**Application number: 2019 / 90725 – Land at Busker Lane. Scissett. HD8 9JU.
Demolition of Existing Dwellings and Erection of 9 Apartments.**

Having read the details and studied the drawings and documents on your Kirklees website we hereby notify you of our intention to object to Planning Application namely to Demolish the existing dwellings and erect 9 no. Apartments.

Proposed Site Plan
Scale 1:200

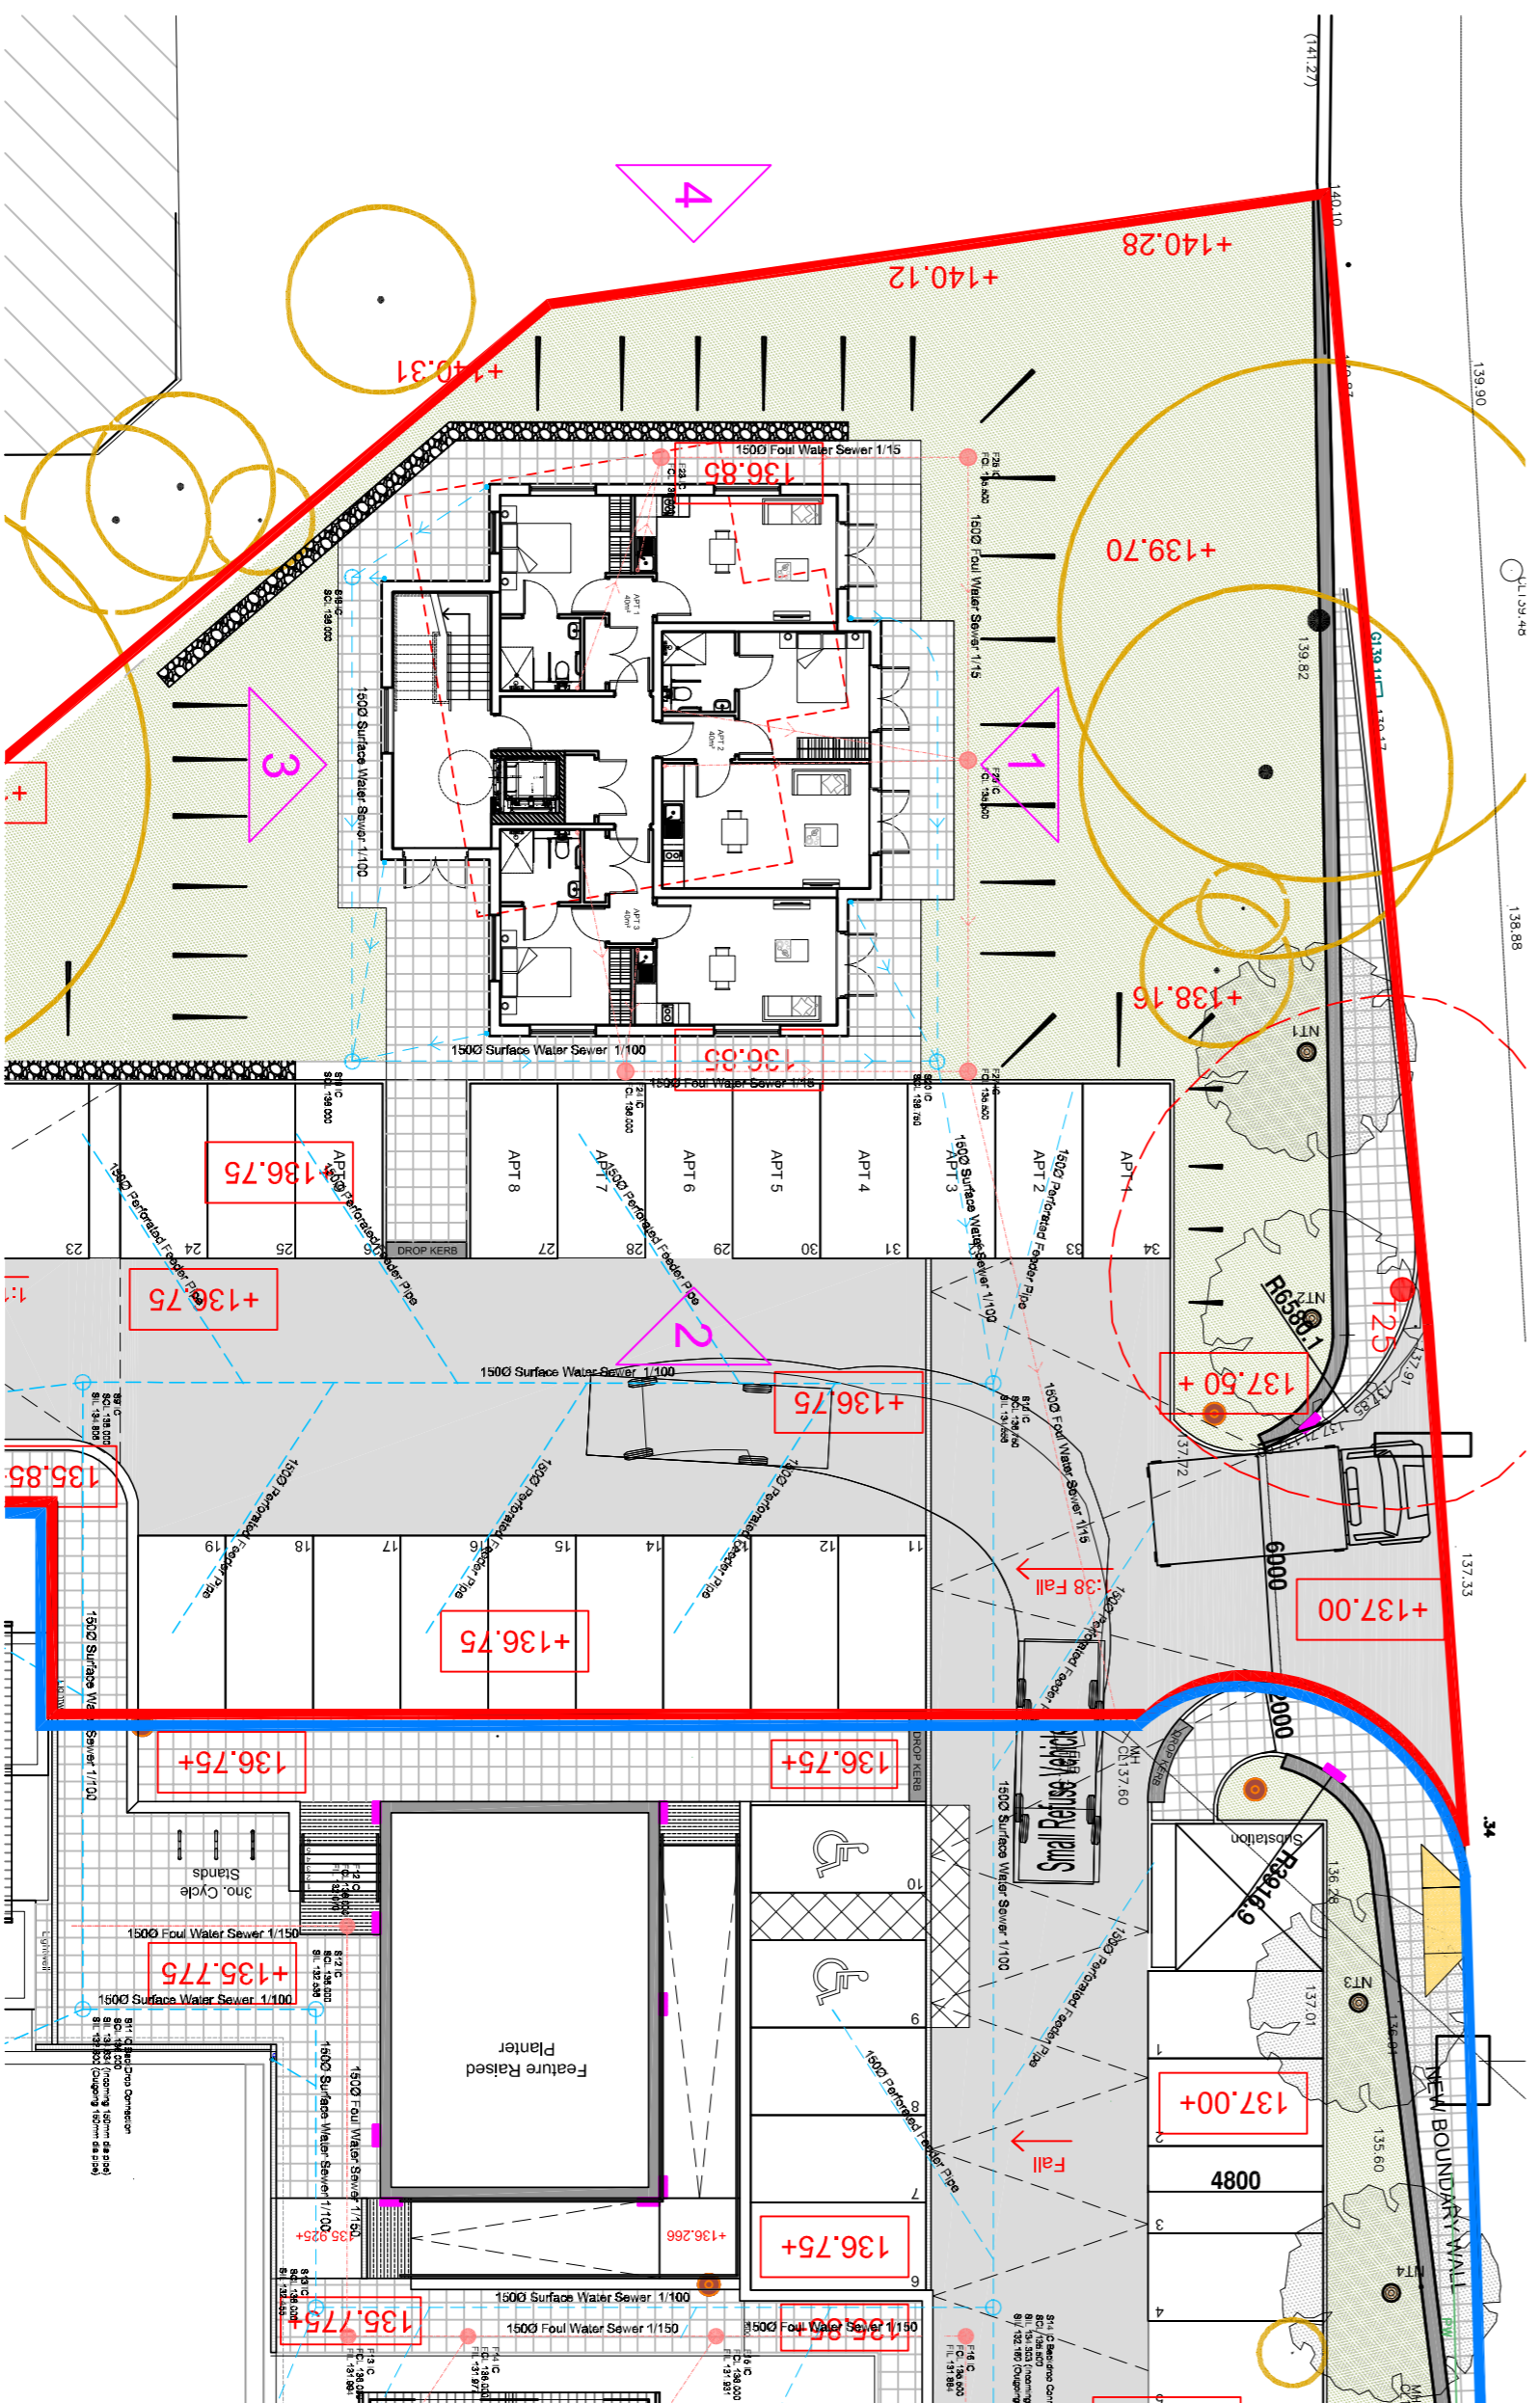
3. The result of this increased density is an increase to vehicular activity. The present car parking for the Care Home has been modified due to a late application for a sub-station which has now decreased the parking provision. With a further 9 dwellings proposed - where are the extra spaces to be found?

7. There is inconsistency in the submitted planning drawings in particular the Car Parking and what is currently available space wise on site. The car parking spaces do not match. As stated in item 3 above, the “proposed” application for a sub-station has reduced the numbers of car parking spaces from 27 spaces for the Care home (*+3 for the existing semi-detached house*) on the original application in 2017. To 23 spaces for the Care home (*+ 9 for 9 new proposed apartments*). Is this going to be allowed?
